**Recommendation:** Refusal

**Applicant:** Mr R Bratt

**Proposal:** Erection of garage adjacent to approved dwelling and change of use of agricultural land to residential use

DRAWING:  
**Proposed Elevations (Sheet 1 of 2)**

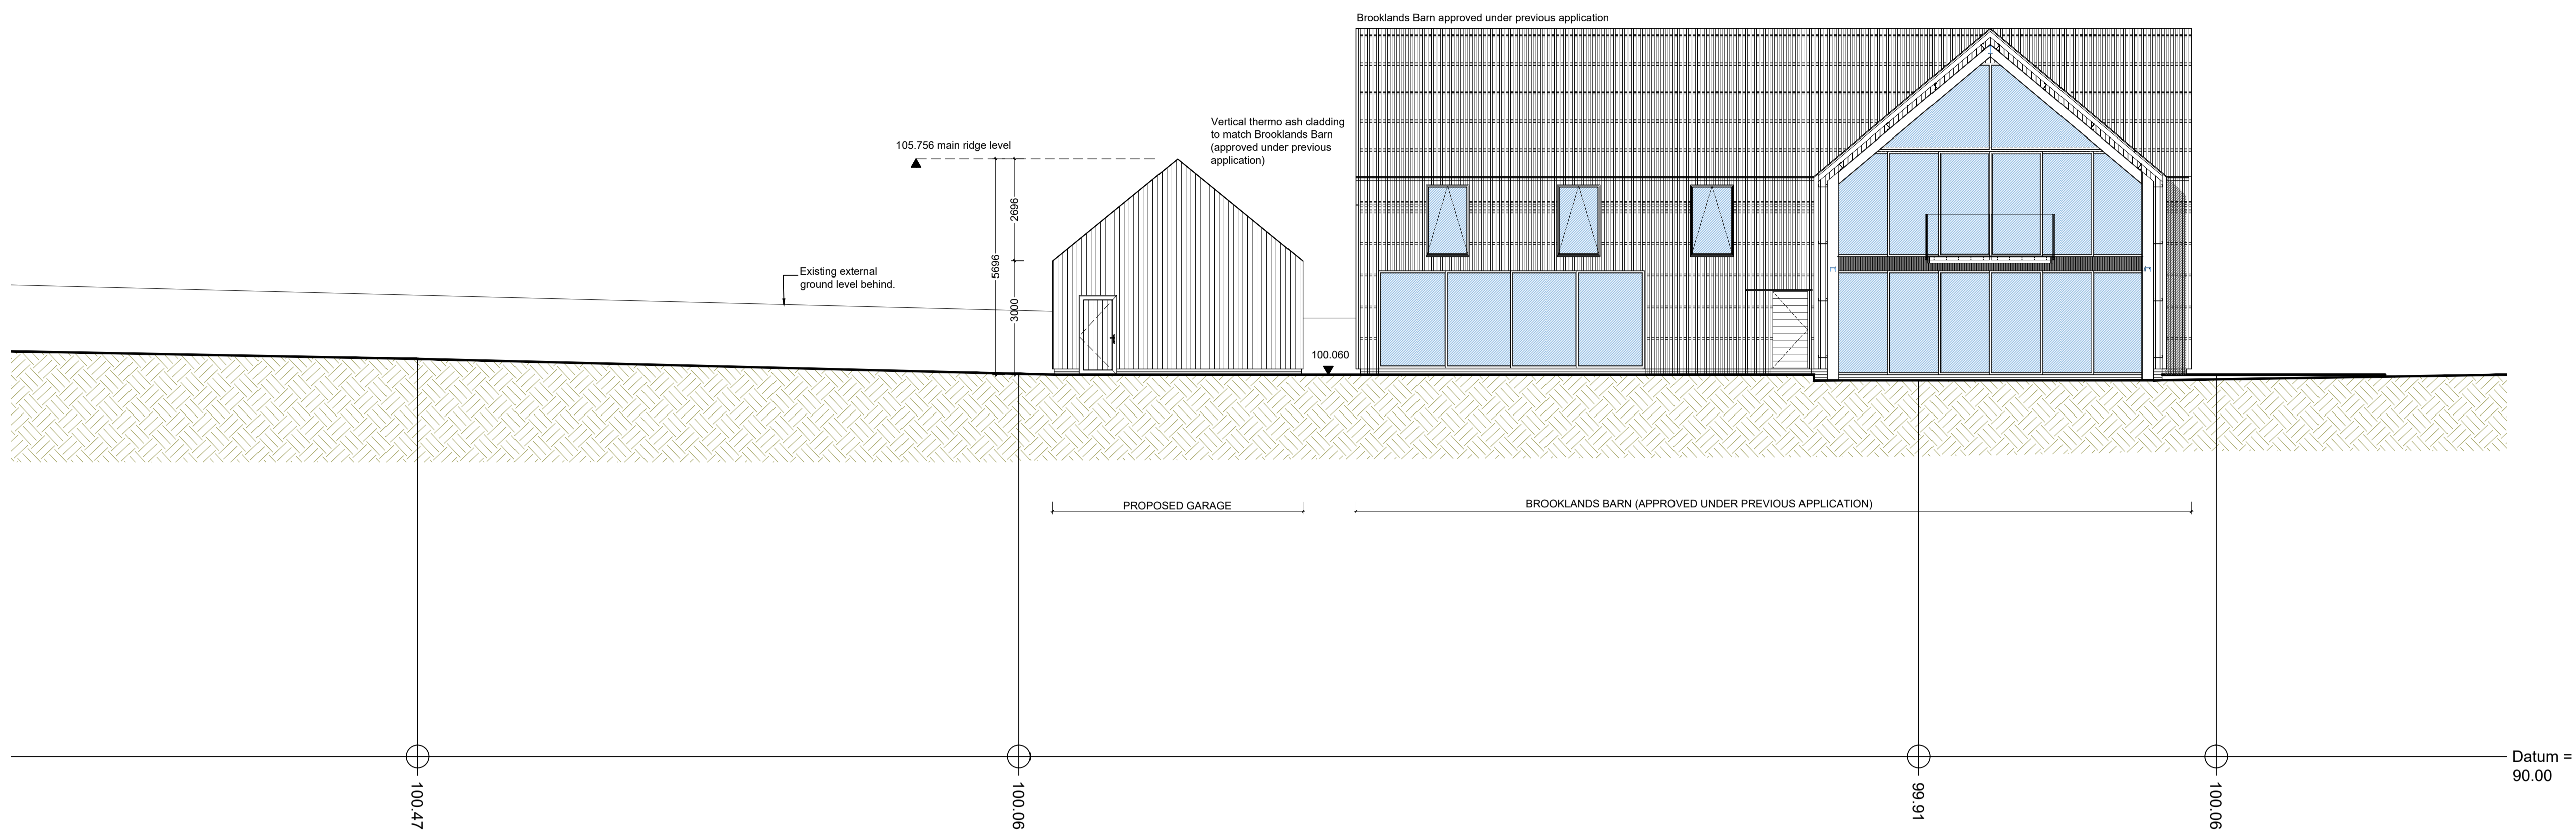
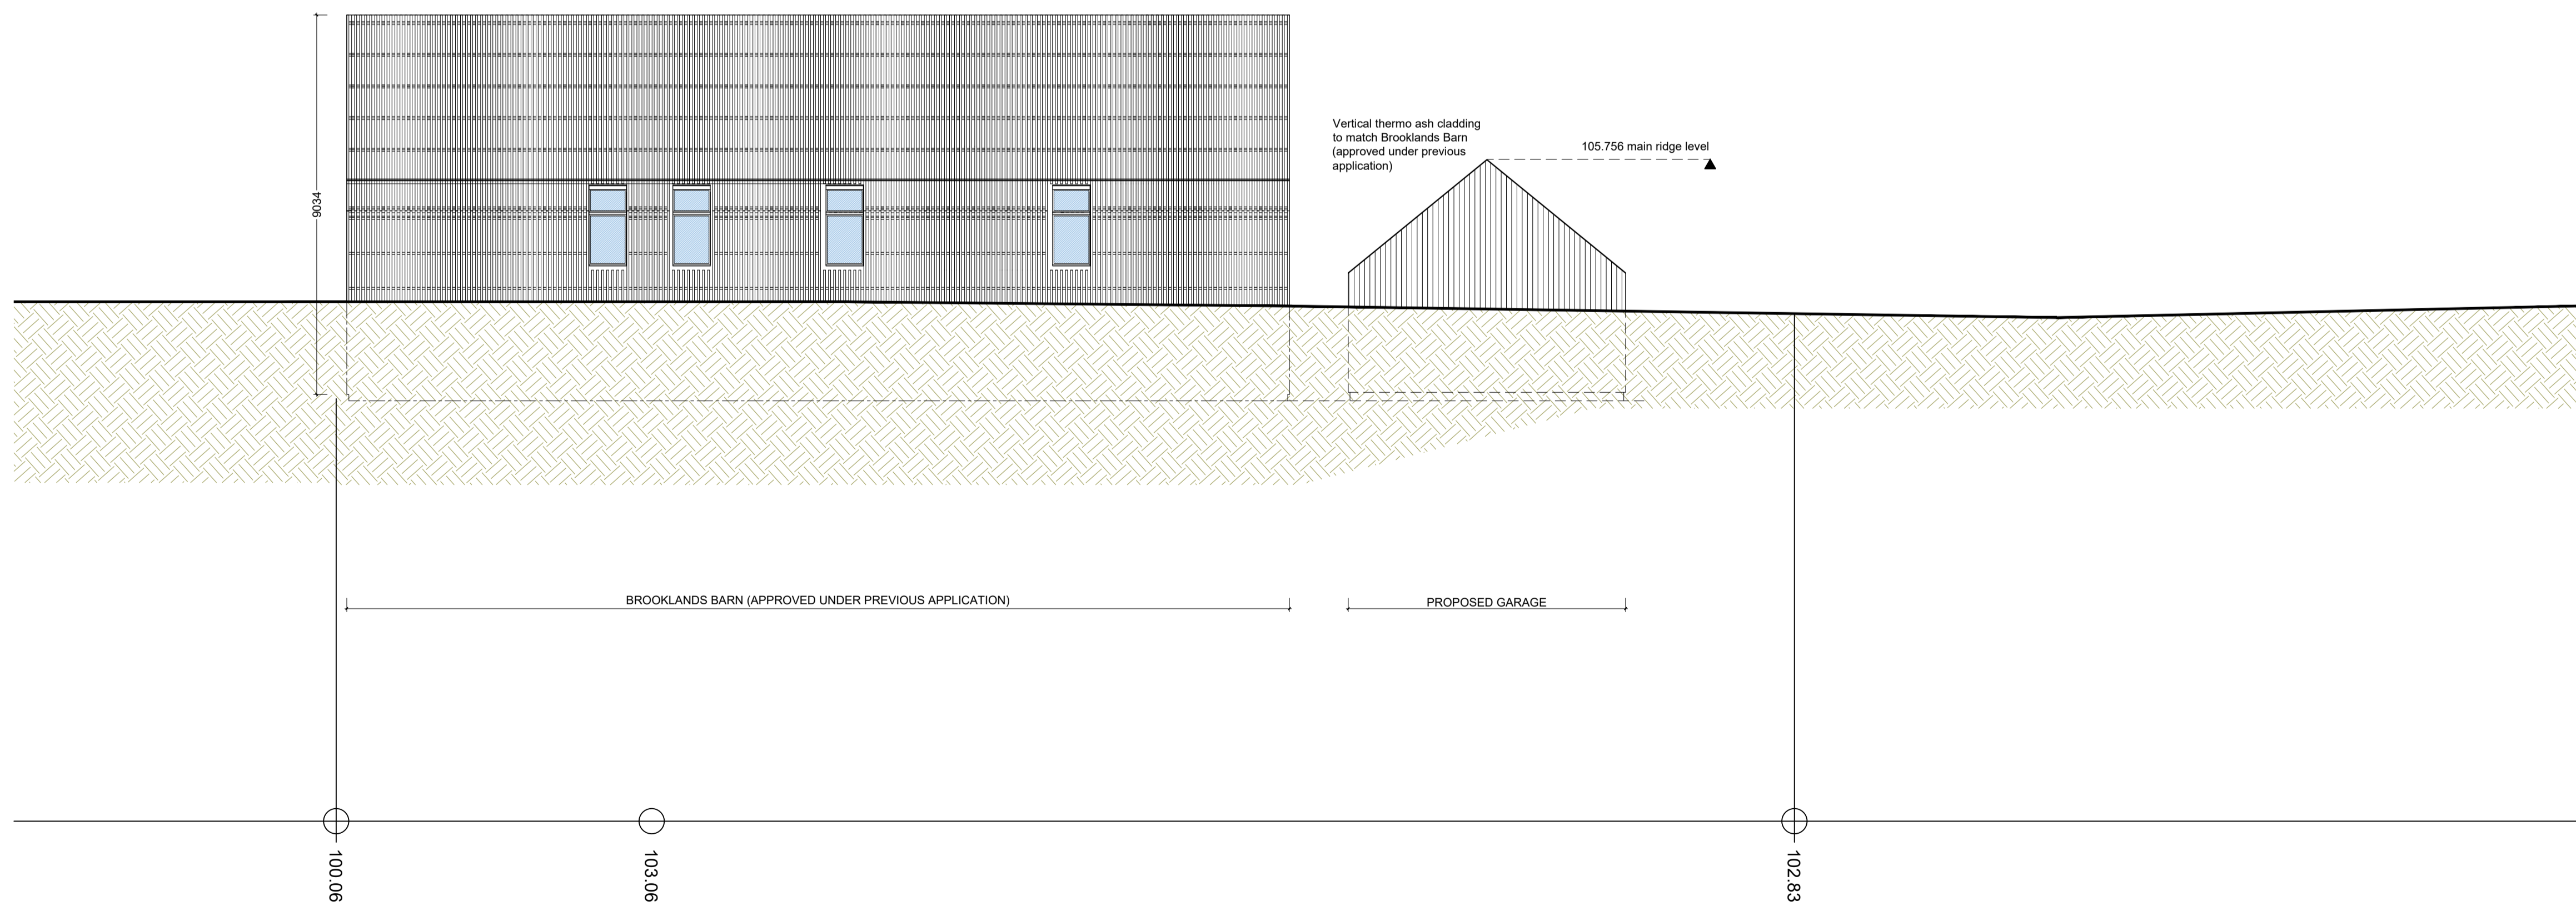
8.5. The proposed building (a 5-bay garage) would be a substantial building, of a scale above that usually expected for a 5-bedroom residential property; with a footprint of 127 sq m that would be almost a third of the size of the footprint of the main dwelling (in itself a substantial building), with a further 127 sq m of hardstanding to the front of the garage building for parking and manoeuvring. The applicant contends that the ancillary building would provide domestic garaging for the applicant's day to day vehicles; and given the relatively remote location consider secure garage/parking as

- 8.6. As noted above the proposed garage building is *substantially* larger than what might be considered a typical domestic garage. The proposed building would be sited to the north-west of the on-going development at the site and would be poorly related to and appear somewhat divorced from the main dwelling. Whilst materials are proposed to match those proposed on the main dwelling, the overall appearance of the building would appear somewhat more commercial than a residential garage, largely due to the number of bays proposed.
